# Bramford to Twinstead Reinforcement

**Document 8.9.5 (B): Temporary and Permanent Access Technical Note  
– Suffolk County Council**

**Final Issue B  
February 2024**

F-AP10
 85th percentile speed = 31.5 mph,
 recorded at 2x 24-hour ATCs east and
 west of AP
 Design speed = 50 kph
 X-value = 2.0m
 Y-value = 70m (desirable minimum)

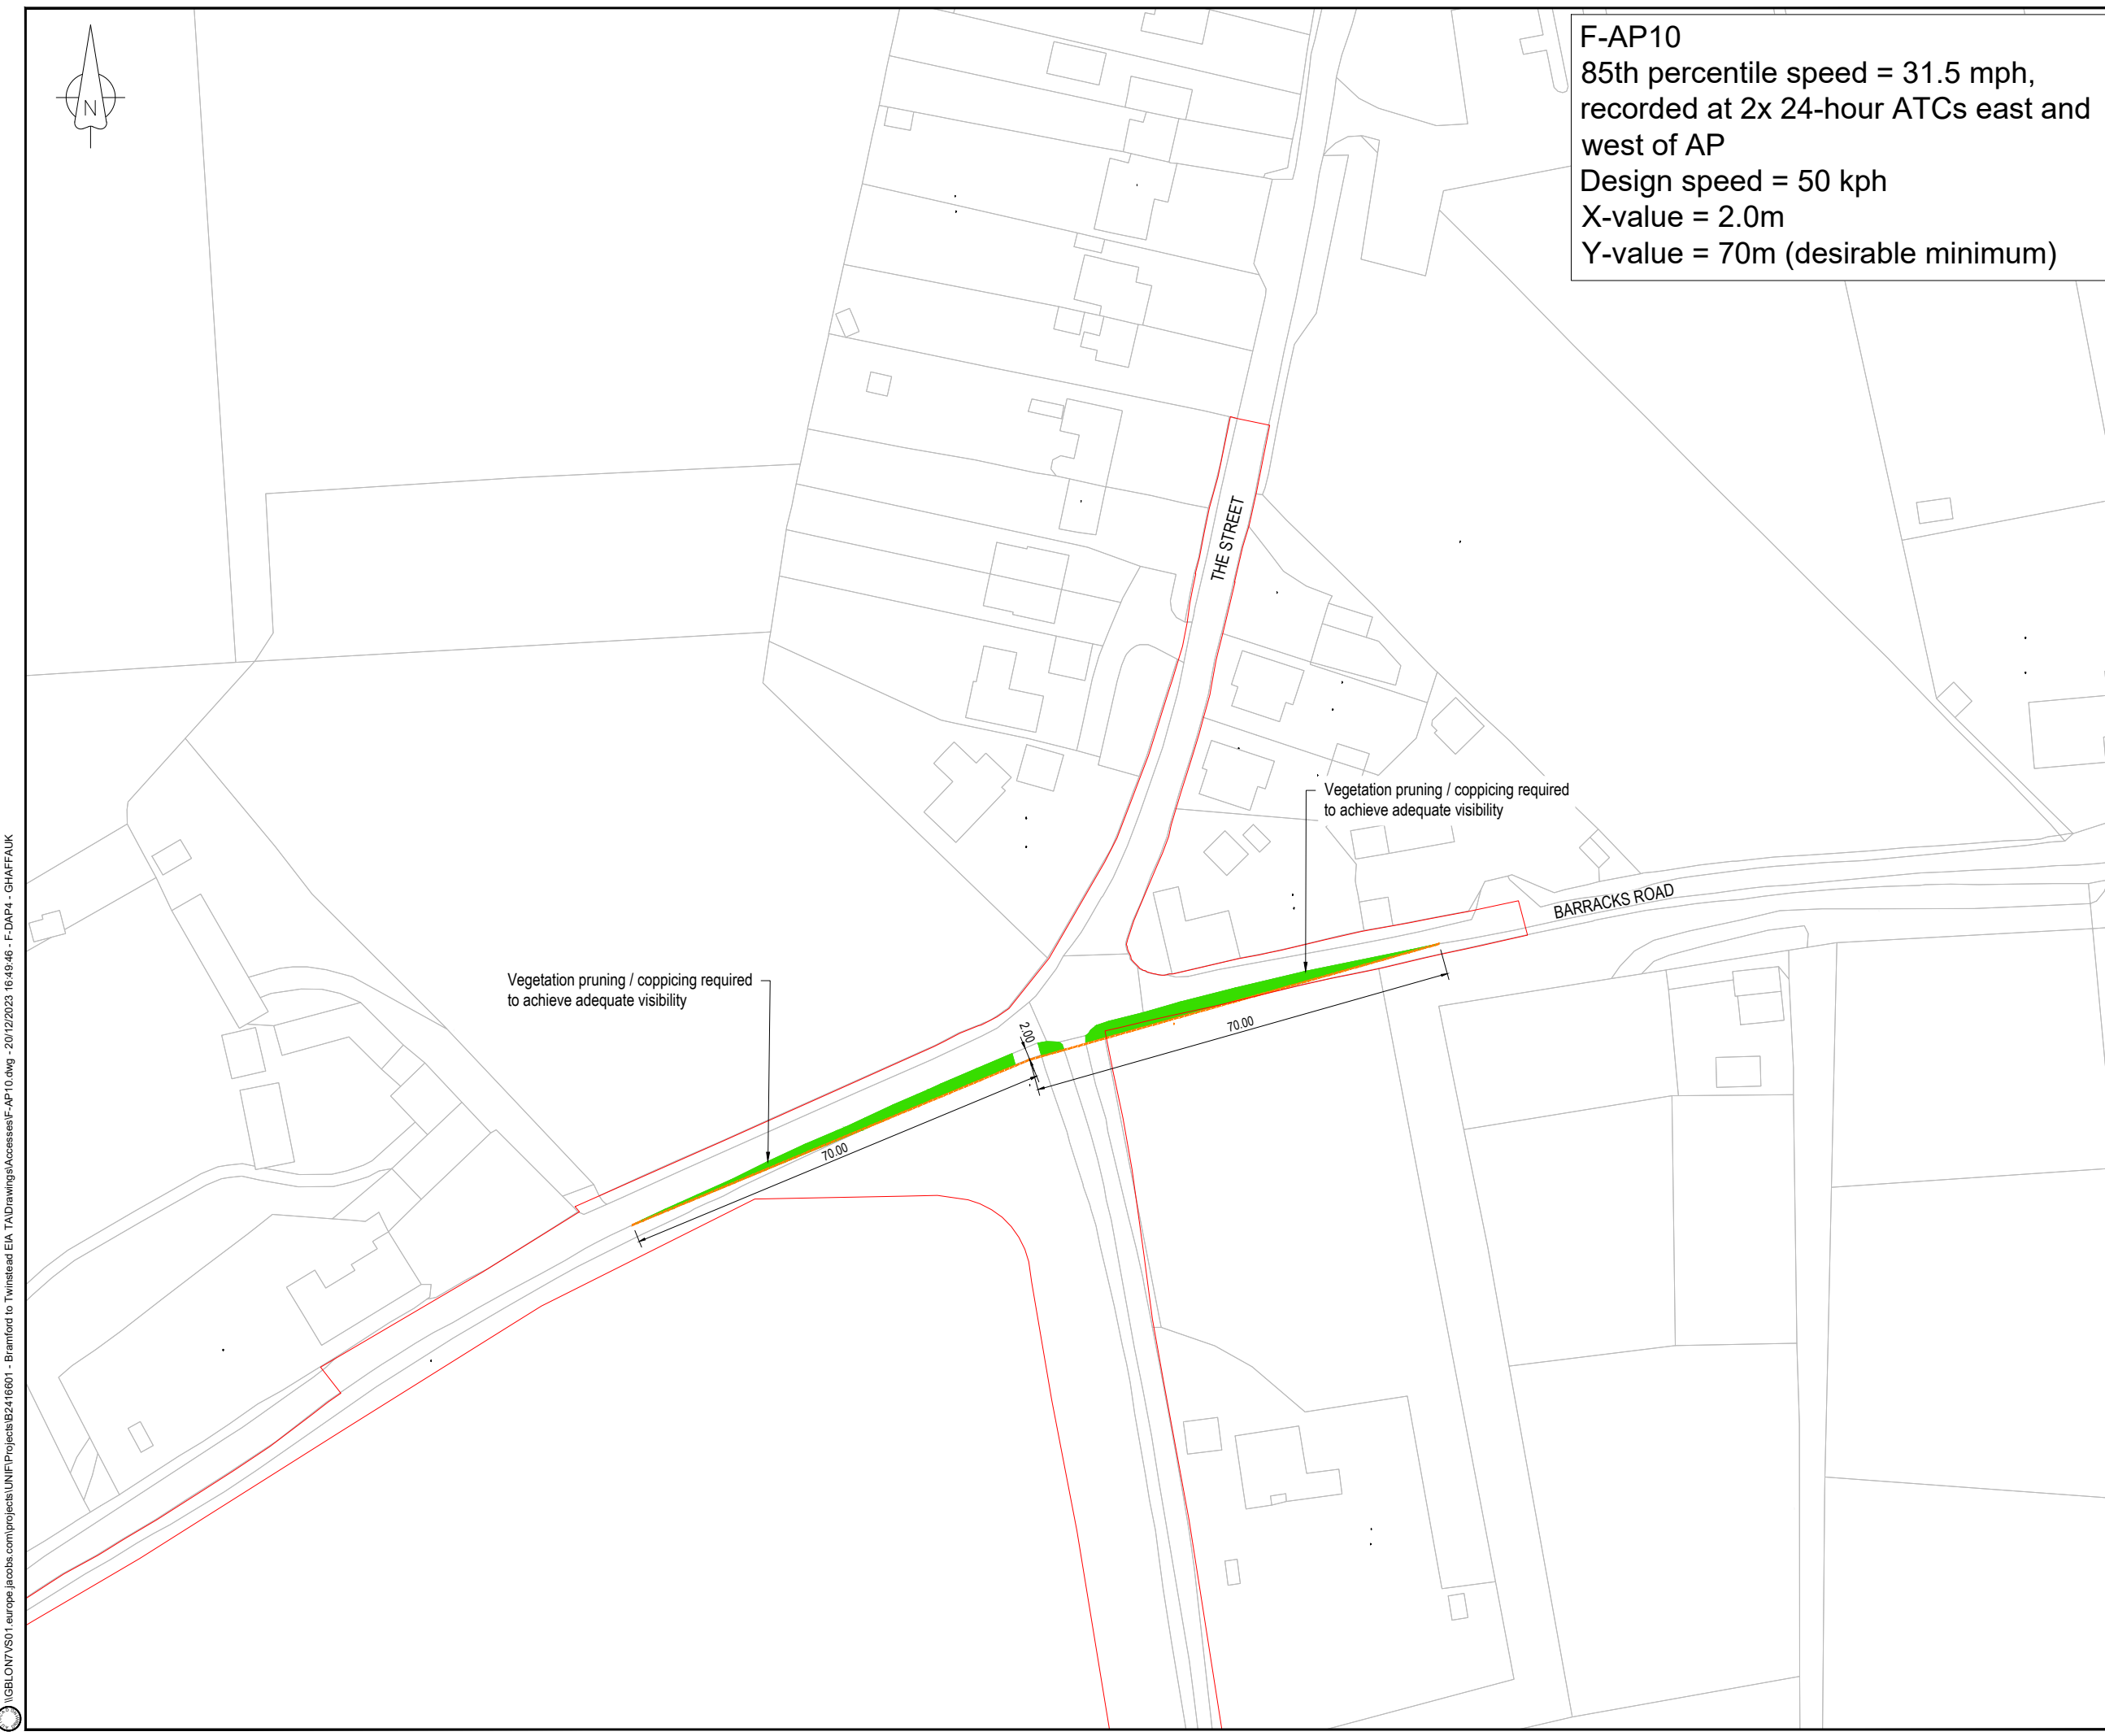
- 2.8.5 In initial discussion with SCC, it was noted that:
- The side road of Barracks Road is approaching a give way line so design speed might reasonably be much lower than that assumed based on nearest free-flow survey locations; and

- Signs and salt bin locations are likely to be back of highway, which might mean highway boundary is not where it might have been assumed to be. Salt bins may be parish owned and not in public highway.

The combination of these aspects means that a lesser visibility splay on the east side may be appropriate, meaning that an appropriate visibility splay can be achieved with no activity outside the highway boundary and/or Order Limits. In addition, a banksman could stand in a position outside the field access where they can see along all three arms of the junction and direct a works driver when it is safe to exit. This type of managed access provides an additional level of provision should it be needed. The banksman would not direct any vehicles except works vehicles. Both options offer potential solutions to delivery of the access in this location.
